Sterling Ranch Comment Response Letter

RE: Sterling Ranch Comments - SF-17-025 - Homestead at Sterling Ranch Filing No. 1.

Enclosed are the response to comments provided by El Paso County Development Services Department on the Sterling Ranch Project; SF-17-025 – Homestead at Sterling Ranch Filing No. 1, Second Submittal

20 BOULDER CRESCENT, SUITE 110
COLORADO SPRINGS, CO 80903
PHONE: 719.955.5485

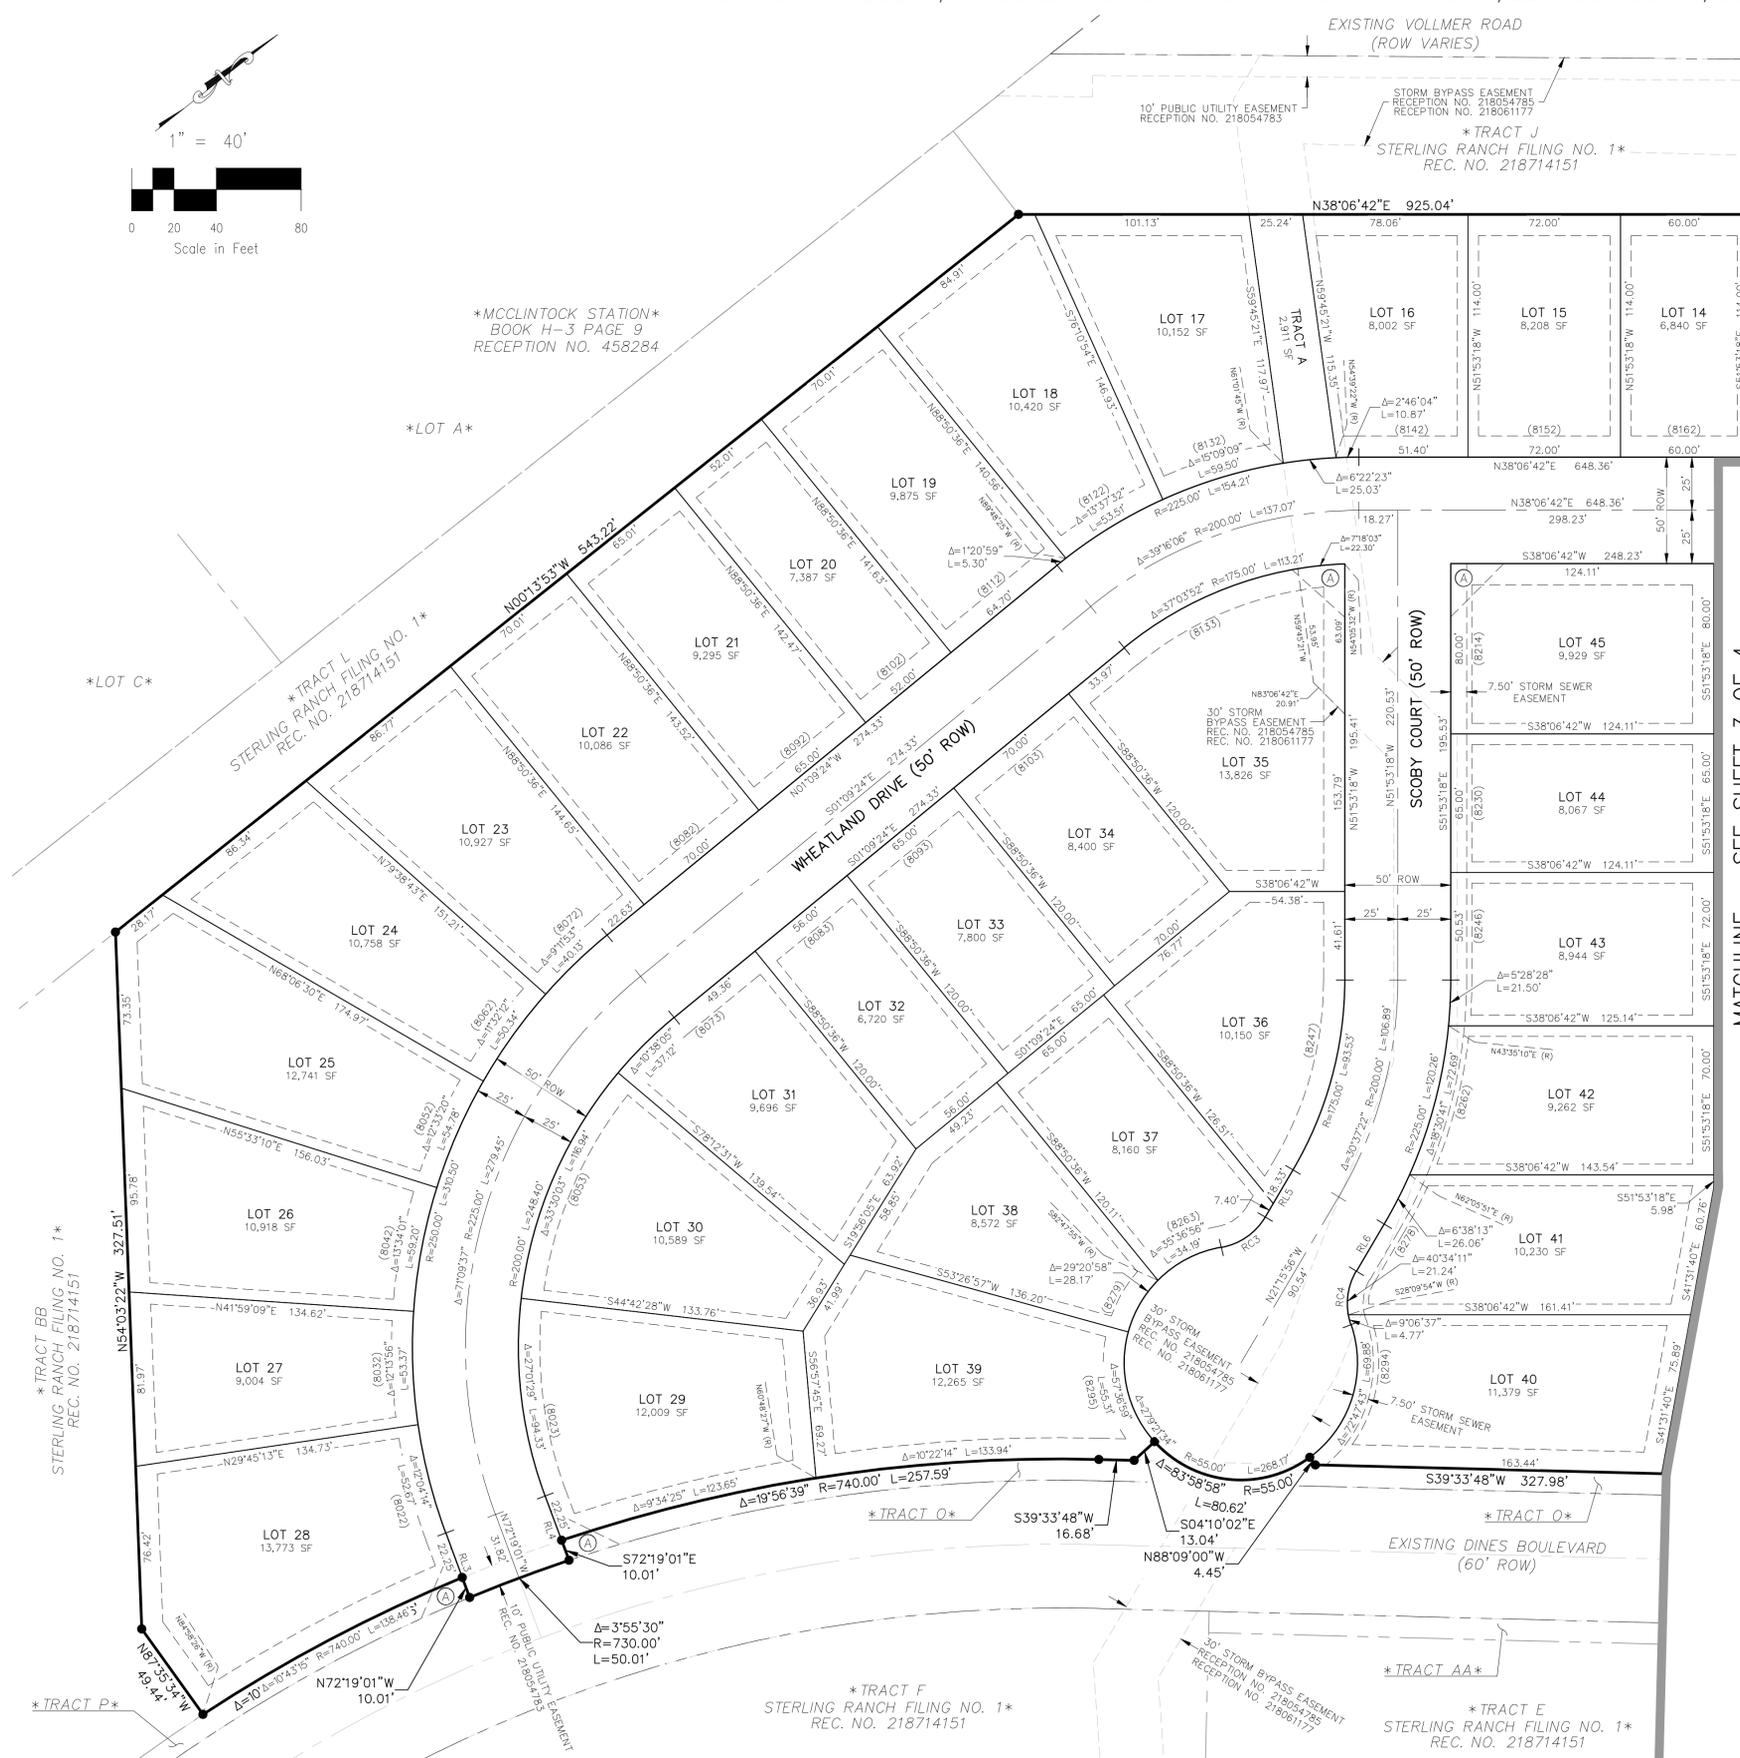
1. **Resolved**
2. See Final Plat redlines for cursory comments. **Partially resolved; see updated redlines.**
Noted.
3. **Resolved**
